PINS Ref: EN010090
DHA Ref: DHA/12321 Doc 14.1

EN010090 – THE KEMSLEY MILL K4 COMBINED HEAT AND POWER GENERATING STATION DEVELOPMENT CONSENT ORDER

DOCUMENT 14.1 – APPLICANT’S SUBMISSIONS FOLLOWING DEADLINE 7

Figure 10.2 - Parameters Plan within the draft DCO (right)

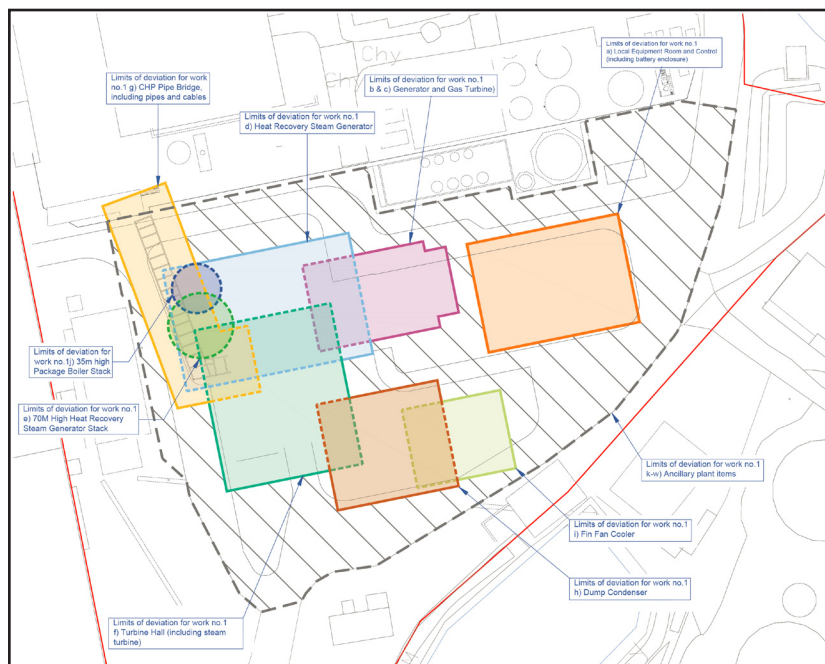
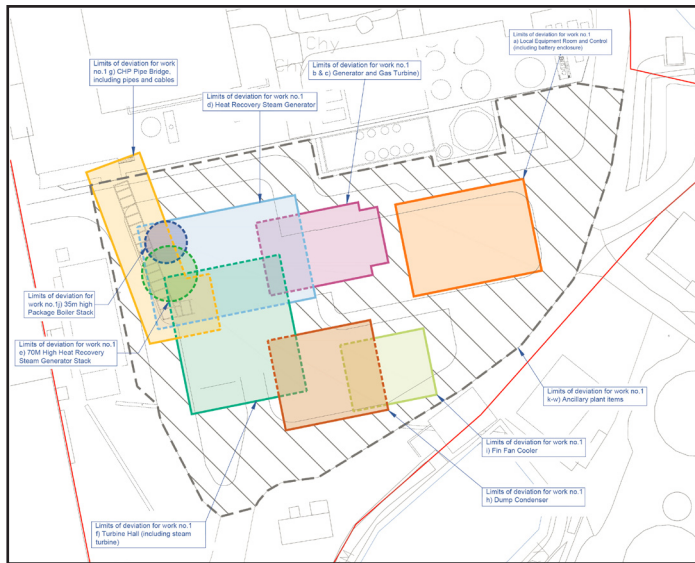
I write further to our conversation following Deadline 7, during which I noted that a discrepancy had been identified regarding the height stated for the Gas Turbine building (Work No1 (c)) at submission. That discrepancy had arisen due to account not being taken of an air inlet structure which will sit on the top of the gas turbine building, thereby increasing its overall height.

Since submission, and therefore throughout the examination of the K4 application, the height parameter stated for the gas turbine has been 9.9m. The addition of the air inlet structure will increase the required height parameter to 14.5m.

A revised dDCO has been submitted (including clean and tracked versions) which reflects the change in Table 1 to the height of the gas turbine building.

A revised version of the Design and Access Statement has been submitted, as that would be a certified document for the purposes of the DCO. The amended version reflects both the proposed change to the height of the gas turbine building as well as the change in Table 1 of the dDCO to refer to AOD heights.
